NSW RURAL FIRE SERVICE

Your reference: SSD-10457
Our reference: DA20210215000597-SEARS-1

State Significant Development – Commercial Premises
Request for comments – exhibited Environmental Impact Statement (EIS)
Eastern Creek Retail Centre - SSD-10457 Rooty Hill Road South Eastern Creek NSW 2766, 1//DP1267436

The New South Wales Rural Fire Service (NSW RFS) has reviewed the EIS and provides the following comments;

PROPOSED CHURCH STREET LONGITUDINAL SECTION

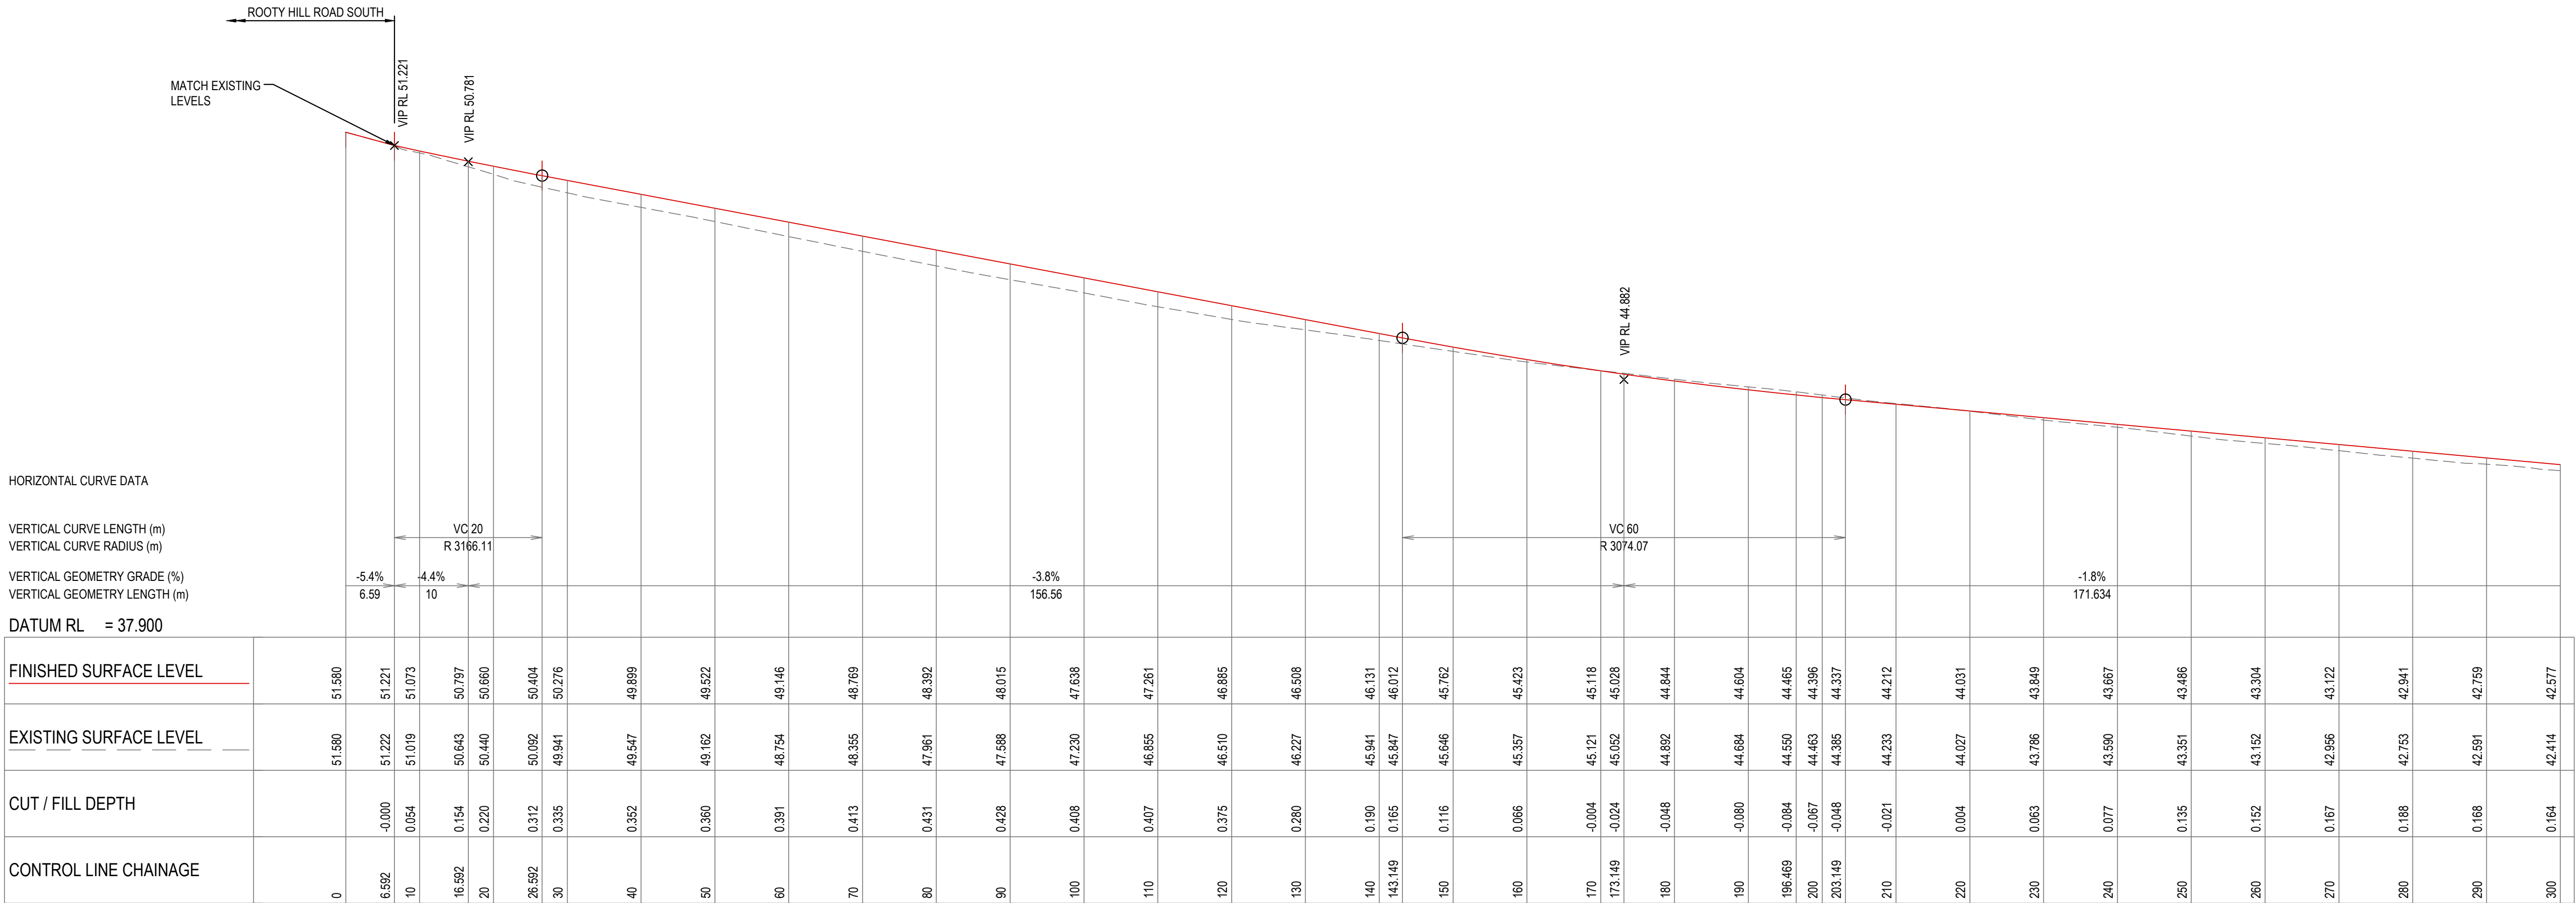
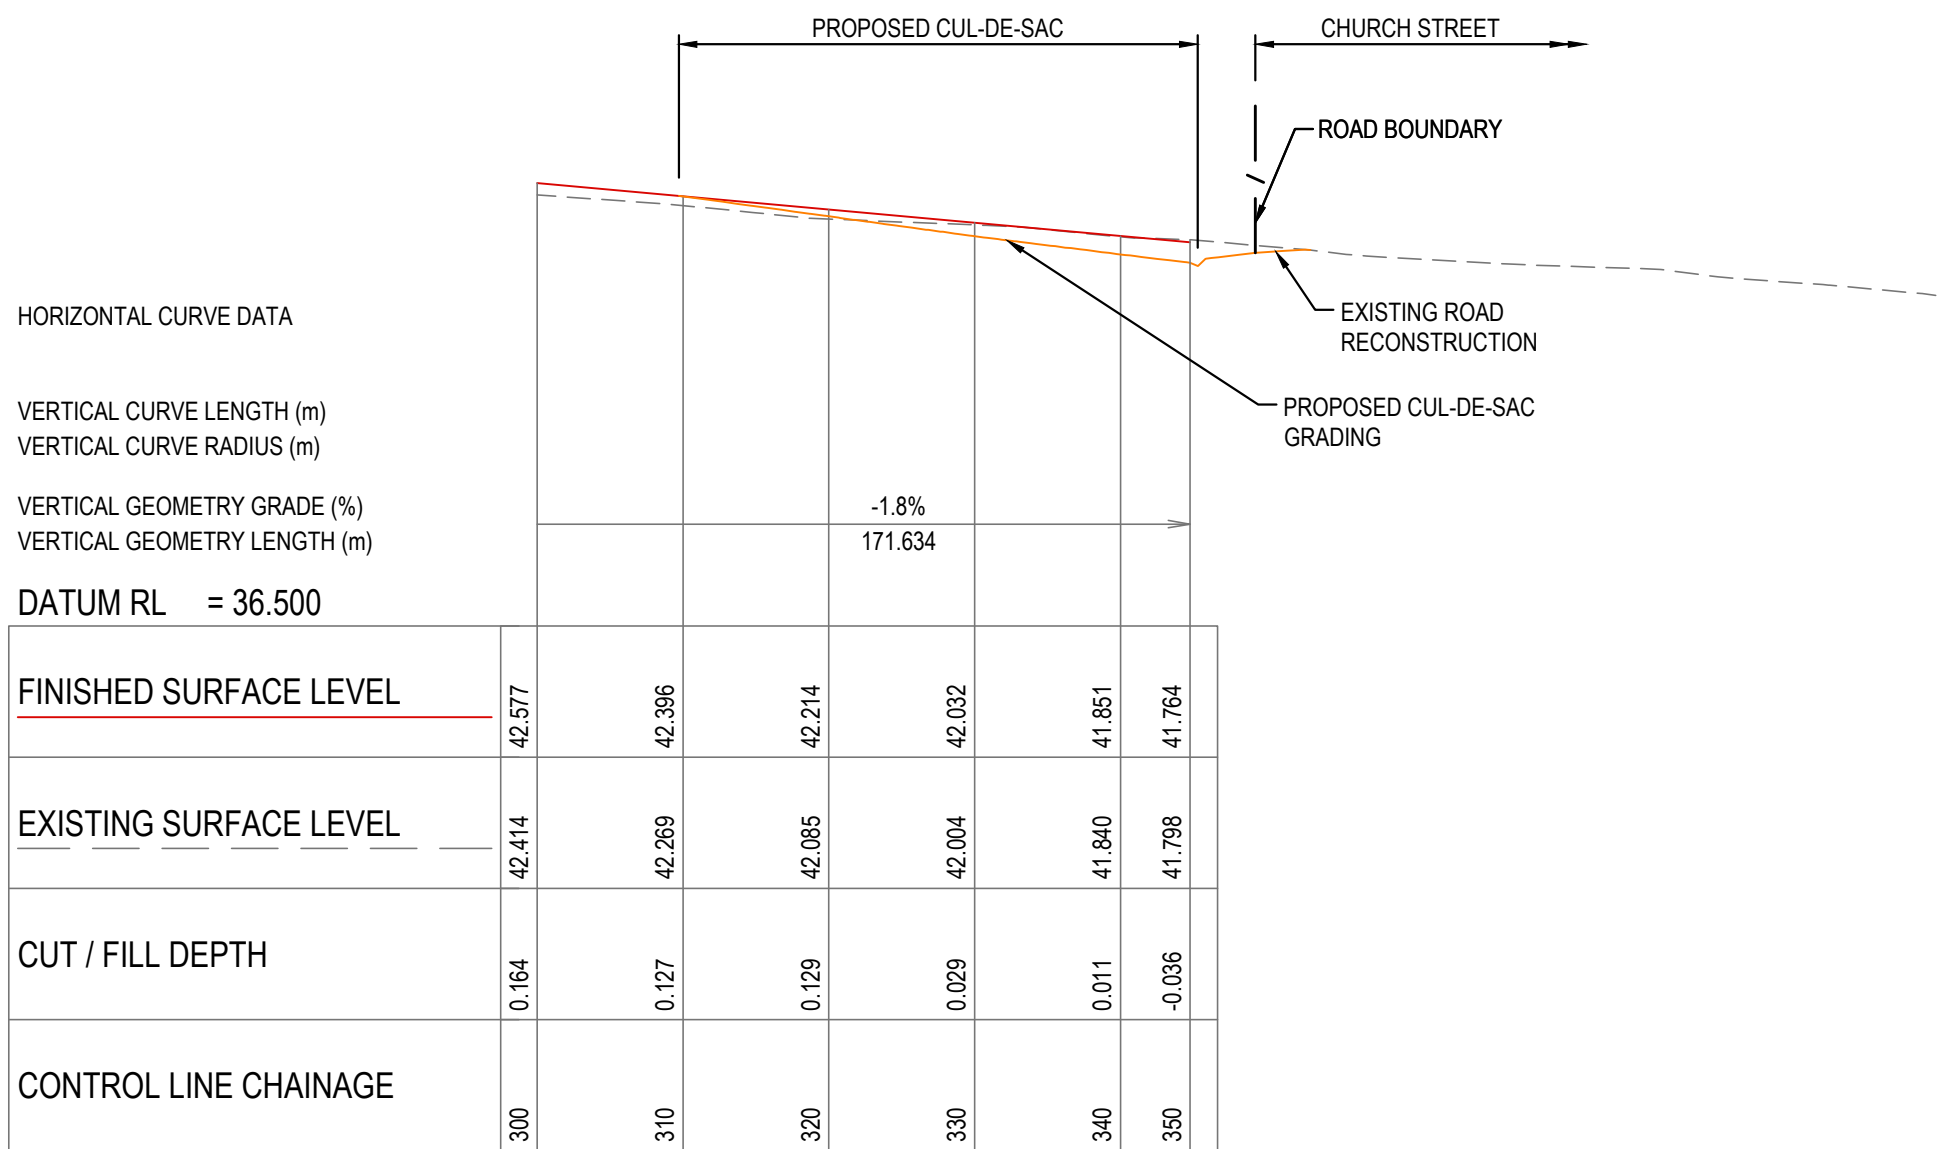
6. Church Street must comply with the following provisions for perimeter roads under Table 5.3b of *Planning for Bush Fire Protection 2019*:

- two-way sealed roads;
- minimum 8m carriageway width kerb to kerb;
- parking is provided outside of the carriageway width;
- incorporate a minimum 12-meter outer radius turning circle, and are clearly posted as a dead-end;
- the capacity of road surfaces and any bridges/causeways is sufficient to carry loaded firefighting vehicles (up to 23 tonnes);
- hydrants are located clear of parking areas;
- curves of roads have a minimum inner radius of 6m;
- the maximum grade road is 15 degrees and an average grade of not more than 10 degrees;
- the road crossfall does not exceed 3 degrees; and
- a minimum vertical clearance of 4m to any overhanging obstructions, including tree branches, is provided;
- hydrants are provided in accordance with the relevant clauses of AS 2419.1:2005 - *Fire hydrant installations System design, installations and commissioning*.
